Application for A Non-material Amendment Following a Grant of Planning Permission

Development Application for a non-material amendment following a grant of planning permission
EG/68/12 - Velux windows

Location 73 Elm Grove Barnham

A	25.02.13	Velux window added to rear elevation	ATC
MK	DATE	REVISION	BY
JOB TITLE			
REAR EXTENSION TO 73 ELM GROVE, BARNHAM WEST SUSSEX PO22 OHW			
DRAWING TITLE			
PROPOSED ELEVATIONS			
SCALE		DRAWING No.	REVISION
1:100 @A3		1019/06	A

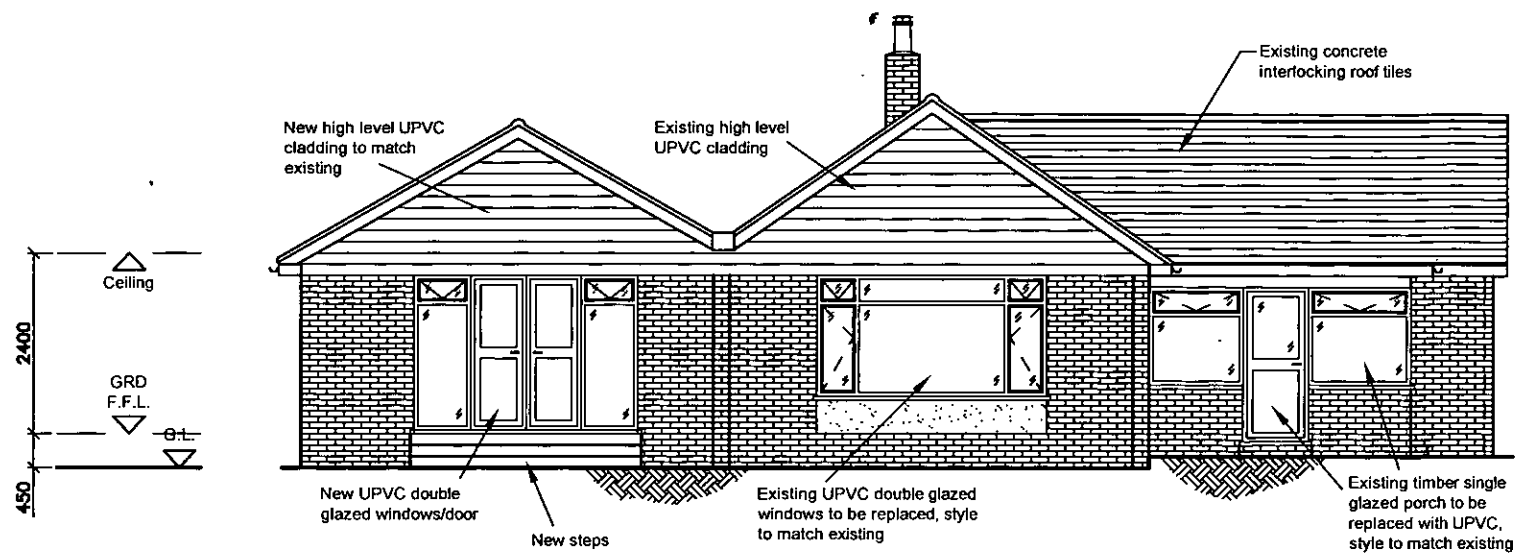
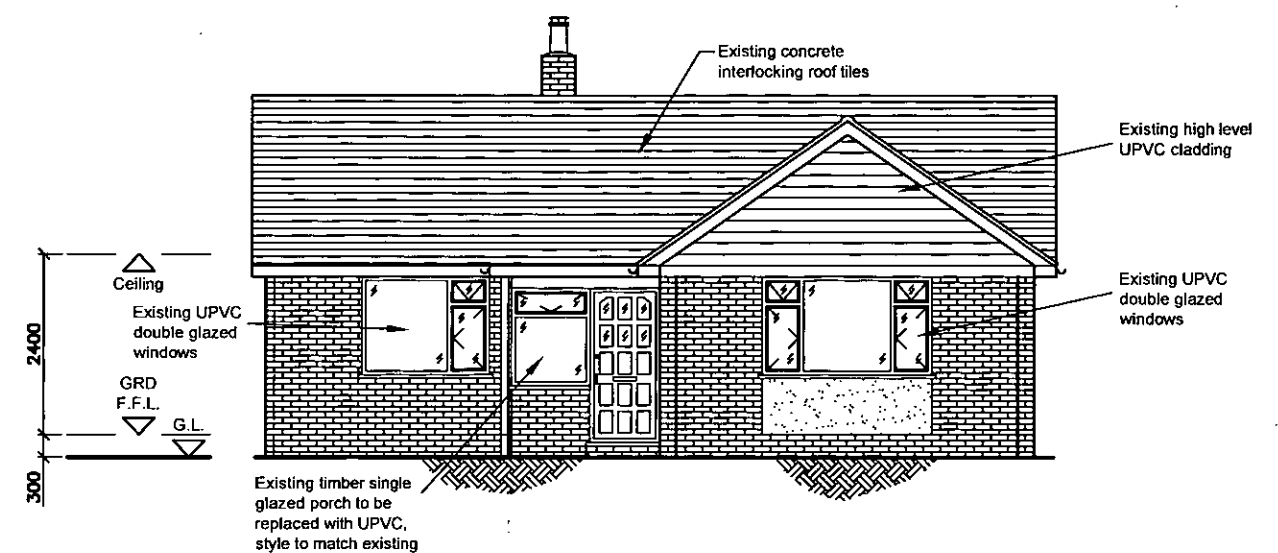
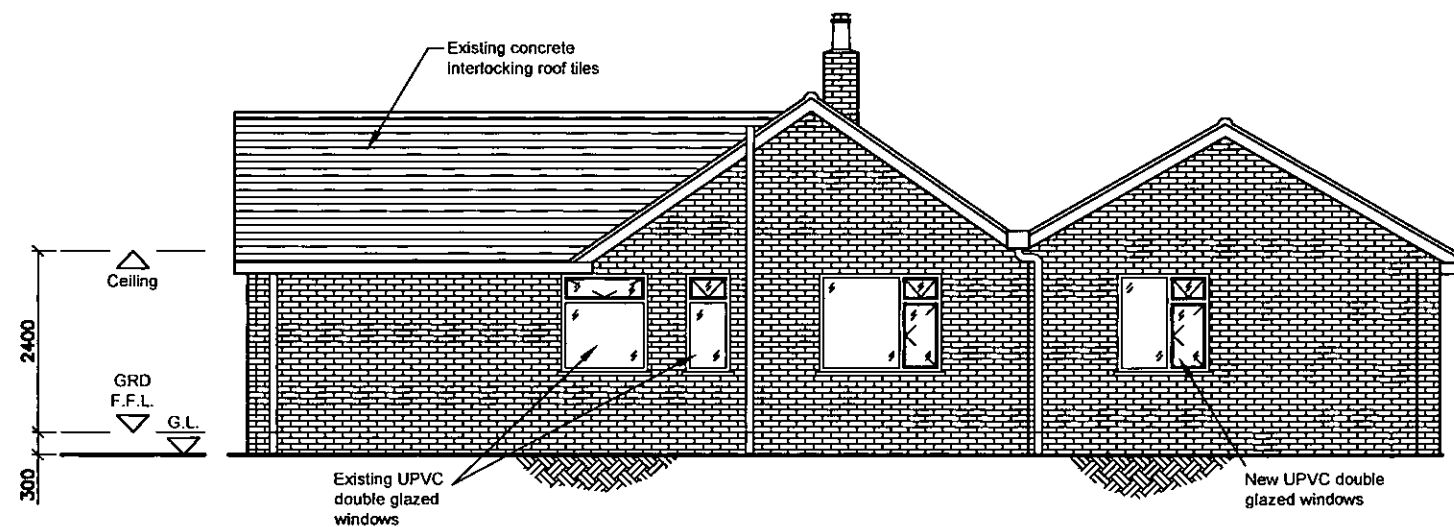
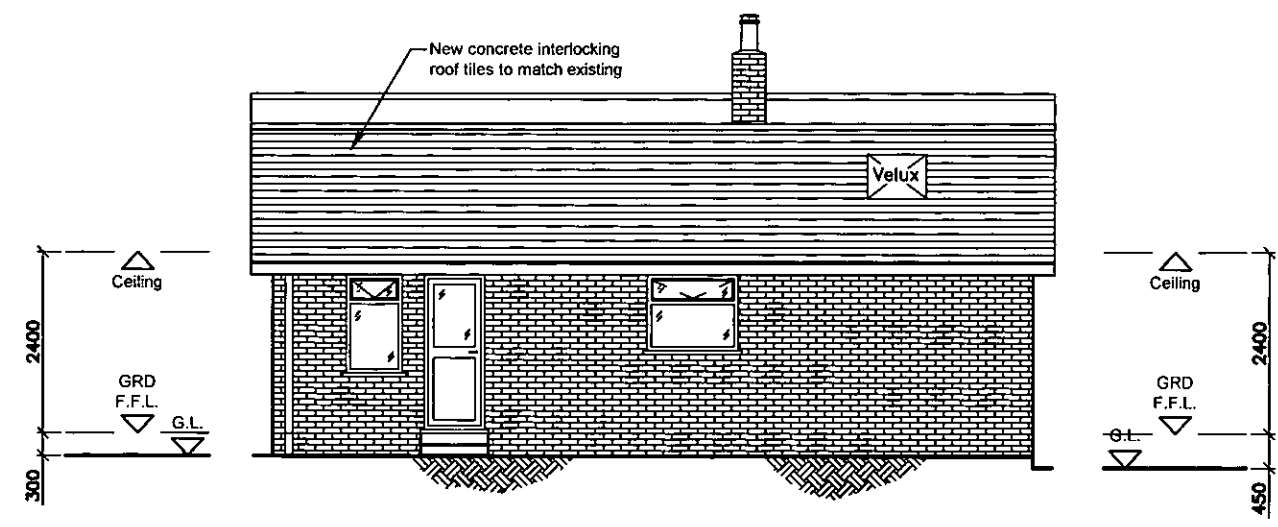
Please submit 1 electronic or 3 paper copies of revised proposed elevations showing both proposed velux windows in accordance with the guidance notes available on our website detailed below (click on National List).
